# Proposed Residential Development at Bearna

Stage 1 & 2 Road Safety Audit

Burkeway Homes Ltd.

July 2020

2 Proposed Site Layout - Public Road works  
1:500

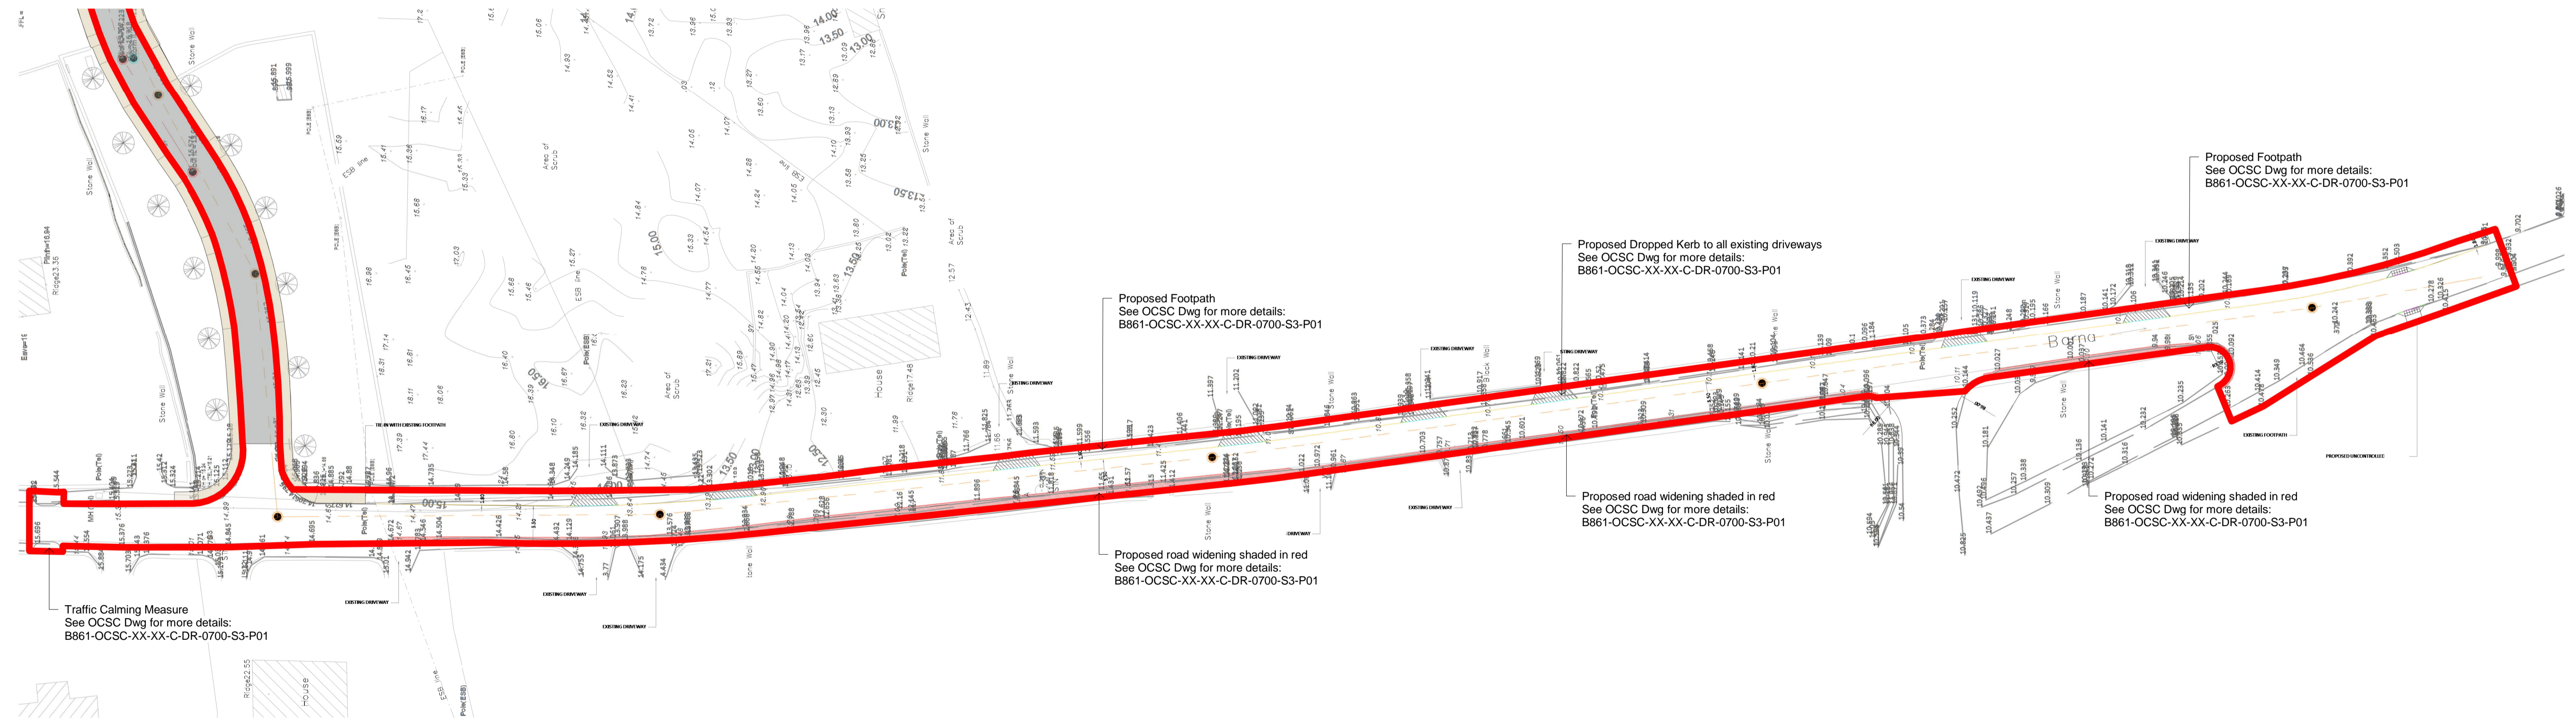
It is unclear if the proposed footpath extends to the existing section of footpath provided at the main development junction. Lack of connection will result in difficulties for pedestrians and conflicts with vehicles.

The Designer should ensure that the connection with the existing section of footpath is provided.

2.1	Yes	Yes	To be addressed in detail design	
2.2	Yes	Yes	To be addressed in detail design	
2.3	Yes	Yes	Connections will be provided.	
2.4	Yes	Yes	To be addressed in detail design

SECTION A - A.
SCALE 1:20

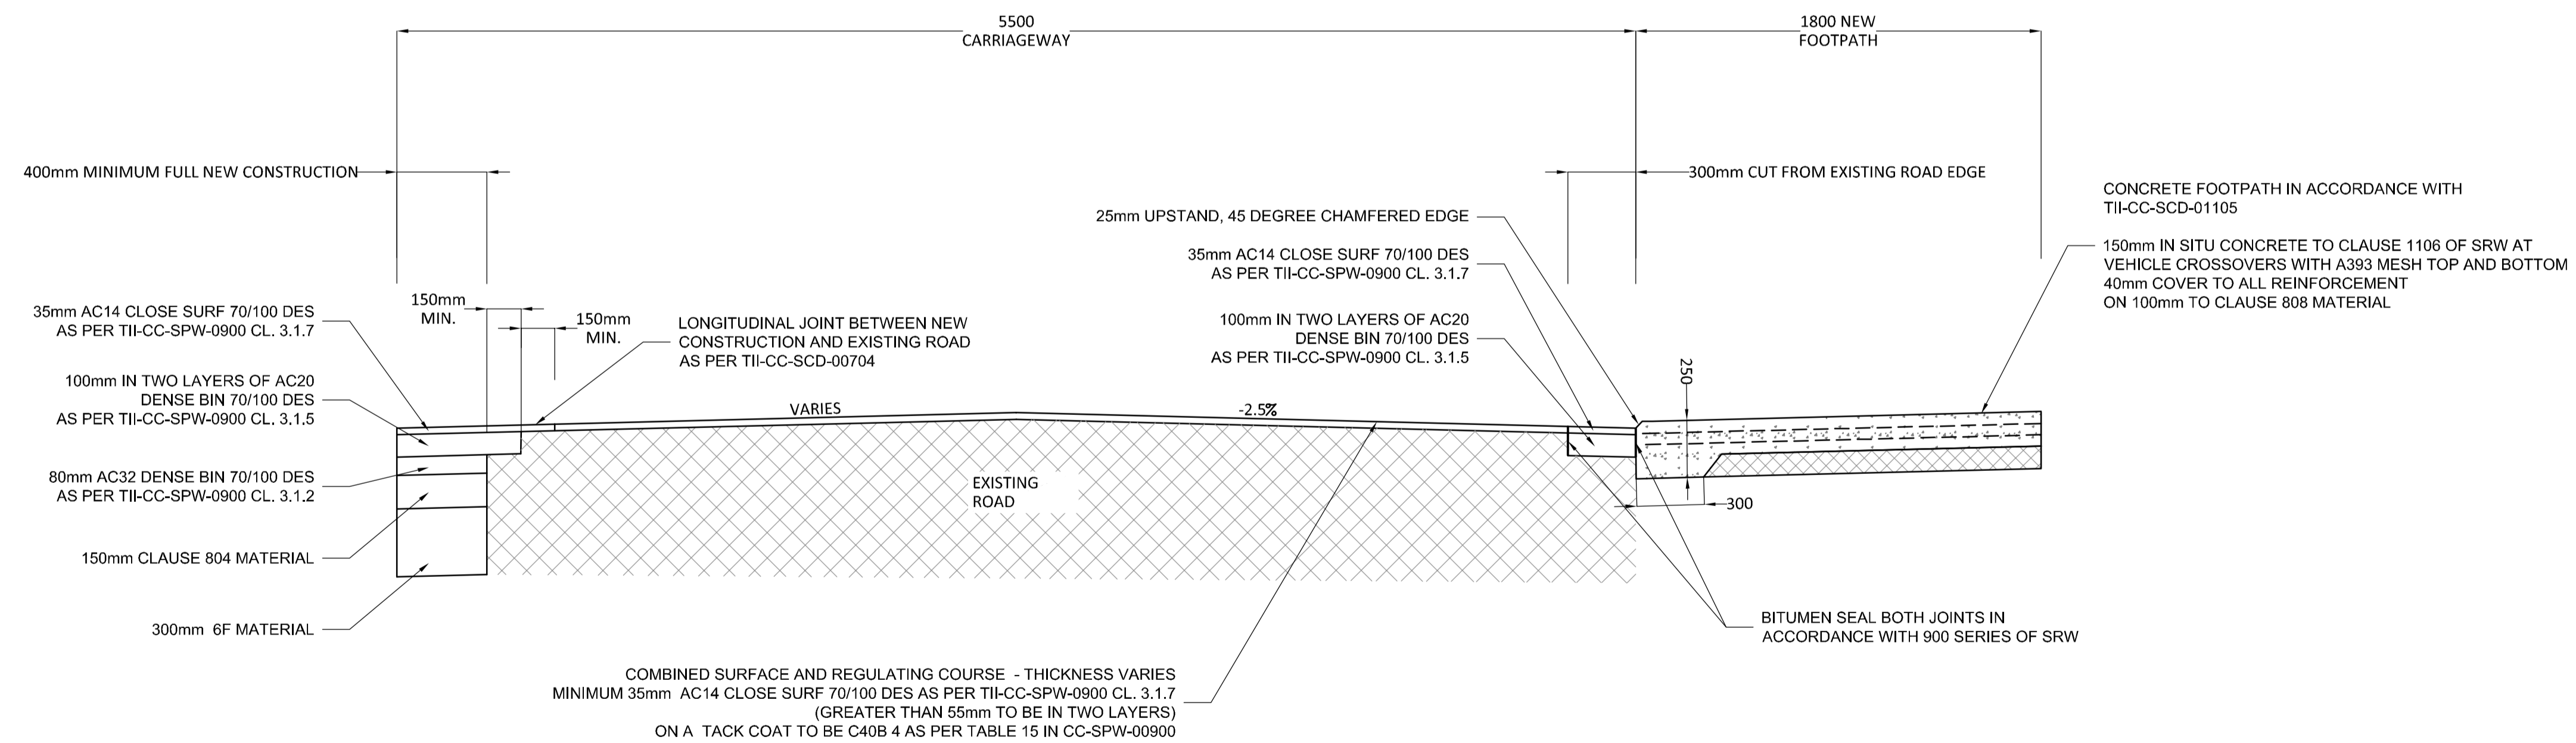
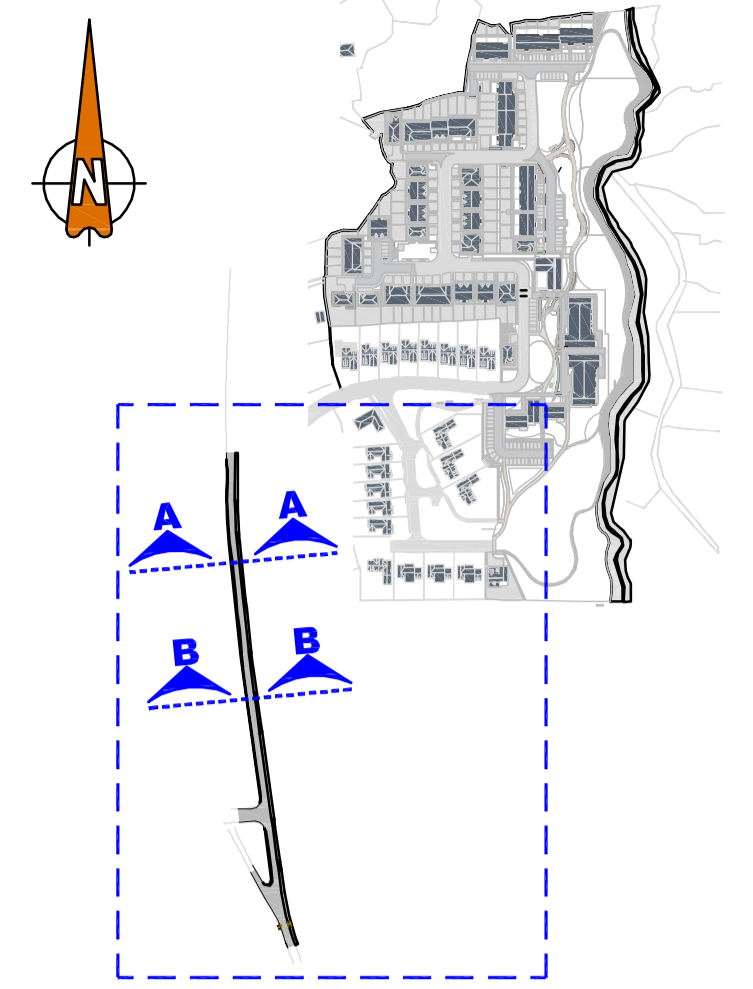
With the installation of the proposed footpath there will be level differences between some of the high-level gardens and the proposed footway. This could result in the following:

- a) Steep gradients at tie-ins between existing driveways and the proposed footway
- b) Inappropriate cross falls on the proposed footway

The Design Team should ensure that tie-in gradients between the proposed footway and the existing driveways are minimized and fall within industry standards.

Phoenix 2 Duo (P2-15W with Elite 6x4 chassis)

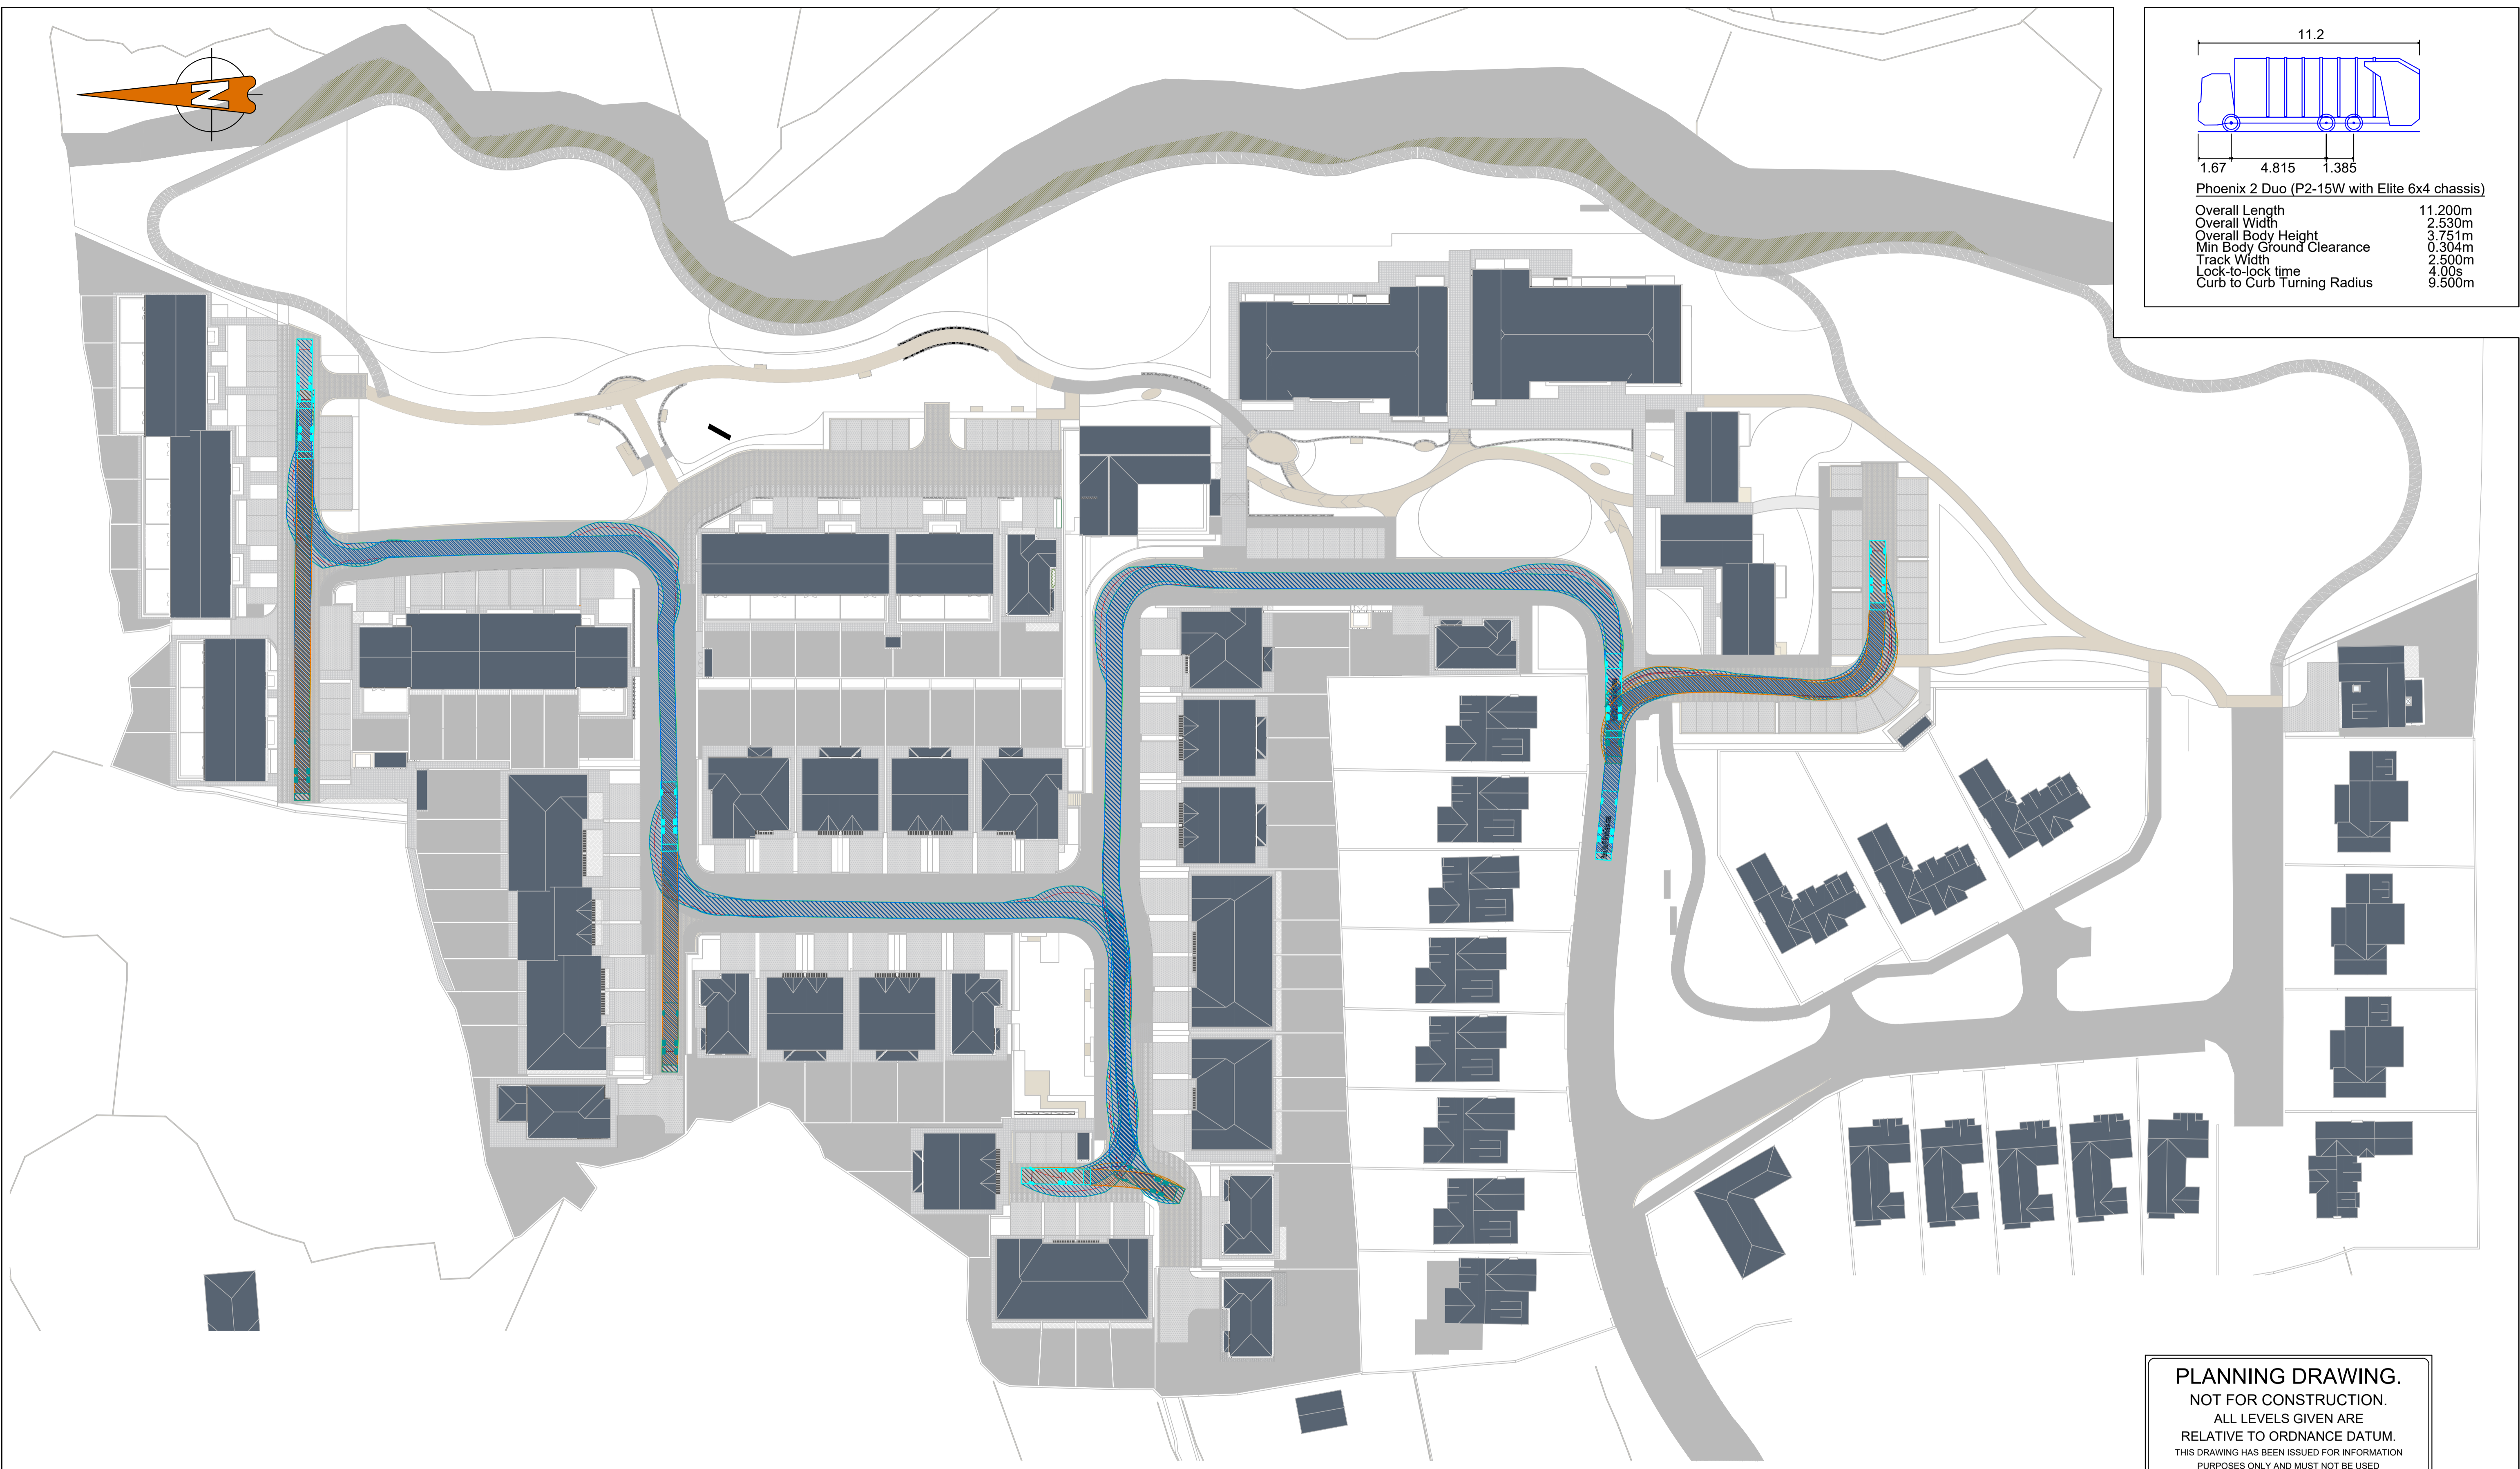
Refuse Vehicles may be required to manoeuvre and reverse on many of the spur streets throughout the site. Some of these spur streets do not appear to include turning heads and which could result in lengthy reversing manoeuvres.

The Designer should ensure adequate turning facilities are provided for Refuse Vehicles where required.

2.8	No	No	Autotrack has been done using the refuse truck and it works as required for waste collection.	Yes
2.9	No	No	Please note that the designer will make the client and the PSDP aware of this risk through design risk assessment and ask them to address the same through preliminary health and safety plan.	Yes
